KIRKLEES METROPOLITAN COUNCIL INVESTMENT & REGENERATION SERVICE

DELEGATED DECISION TO DETERMINE PLANNING APPLICATIONS

Reference No:	2024/62/90282/W
Site Address:	16, Pembroke Court, Crosland Moor, Huddersfield, HD4 5NB
Description:	Alterations to roof and erection of front and rear dormers
Recommending Officer:	Joanna Rednall

HOUSEHOLDER DELEGATED REPORT

Existing South East Elevation (Right)
1 : 50

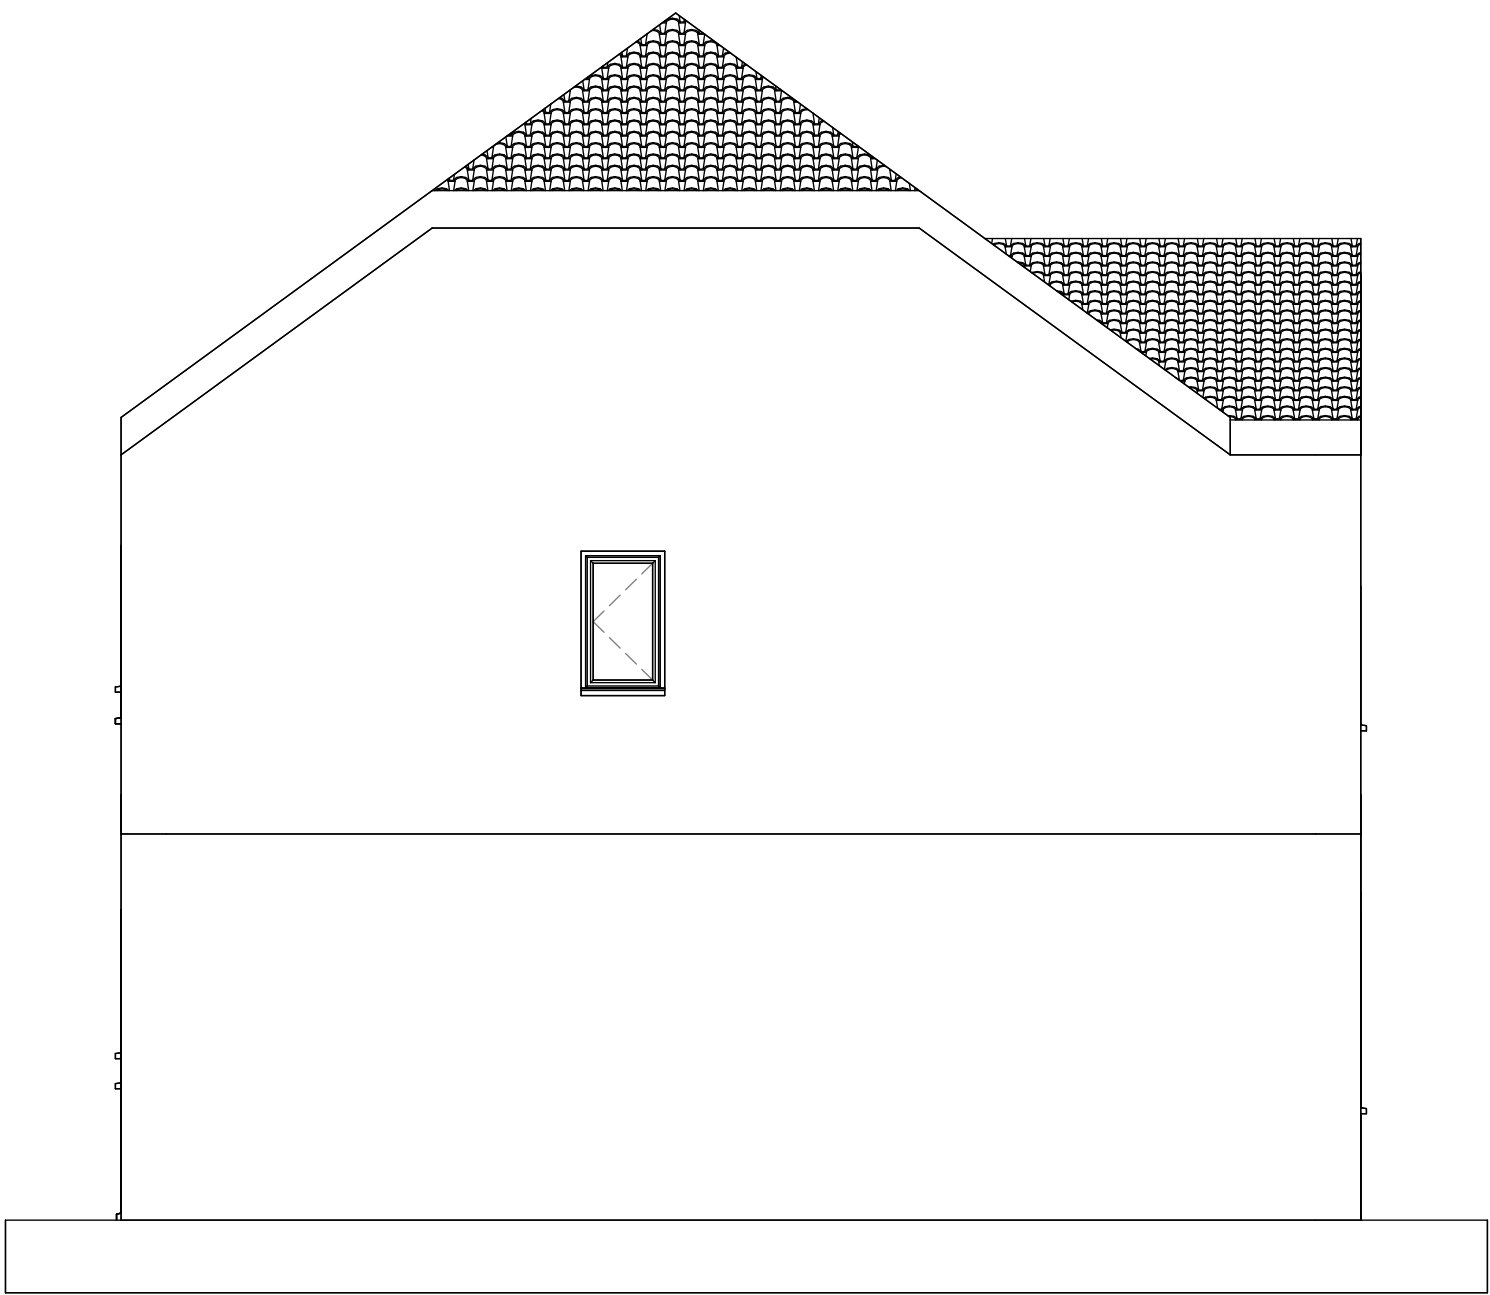
The front dormer is located on the south-west facing elevation. The external walls are constructed from hung tiles with a gable roof. The measurements of the front dormer are as follows:

- ~3 metre width
- ~3.1 metre projection
- ~1.5 metre eave height
- ~2.7 metre total height

The rear dormer is located on the north-east facing elevation. The external walls are constructed from hung tiles with a flat roof. The measurements of the rear dormer are as follows:

- ~4.8 metre width
- ~2.5 metre projection
- ~2.1 metres in height

Dormer extensions should:	<u>Yes - COMPLY</u>	<u>No - JUSTIFY</u>
relate to the appearance of the house and existing roof	Both dormers are set within confines of existing roof.	
be designed in style and materials similar to the appearance of the existing house and roof	Both dormers are faced in hung tiles to match the existing house. Front dormer – gable roof in design to match host dwelling.

not dominate the roof or project above the ridge of the house	The front dormer would not dominate the roof or project above the ridge of the house. Although the rear dormer has a larger width, it is considered that there is sufficient space remaining above the dormer and would not dominate the roof.	
be set below the ridgeline of the existing roof and within the roof plane	Both dormers are set below the ridgeline of the existing roof.	
be aligned with existing dormer windows on neighbouring properties in the same roof plane where relevant	The front dormer has one window and the rear dormer has two windows, all of which will be aligned with existing windows.

• Policy LP24 Design (a) and (c) of the KLP • Chapter 12 NPPF	keeping with the street scene. Following amendments the size of the front dormer is reduced and a sympathetic addition to the street scene. The rear dormer would not adversely impact the streetscene.	
Impact on original house	• KDP2 of the SPD • Policy LP24 Design (c) and (d) of the KLP • Chapter 12 of the NPPF	The dormers are proportionate to the roof and sympathetic to the existing dwelling.	✓
Height, scale and massing	• KDP 1 and 2 of the SPD • Policy LP24 Design (a), (c) and (d) of the KLP • Chapter 12 of the NPPF	Height is acceptable as amended. Neither dormer would project above the ridge of the house.	✓
Facing materials and detailing	• KDP 9 of the SPD • Policy LP24 Design (d) (iii) of the KLP • Chapter 12 of the NPPF	Hung tiles to match existing dwelling considered acceptable.	✓
Roof style	• KDP 1 and 2 of the SPD • Policy LP24 Design (a), (c) and (d) of the KLP • Chapter 12 of the NPPF	Gable roof for front dormer to match existing house. Flat roof for rear dormer typical for rear dormer extensions and reduces overall mass.	✓

YES / NO	SUMMARY
Negotiations/Amendments during course of application	Yes	Negotiations were made with the applicant's agent regarding the size of the front dormer. Amended plans were received 28 th March.
Parish/Town Council comments sought	No
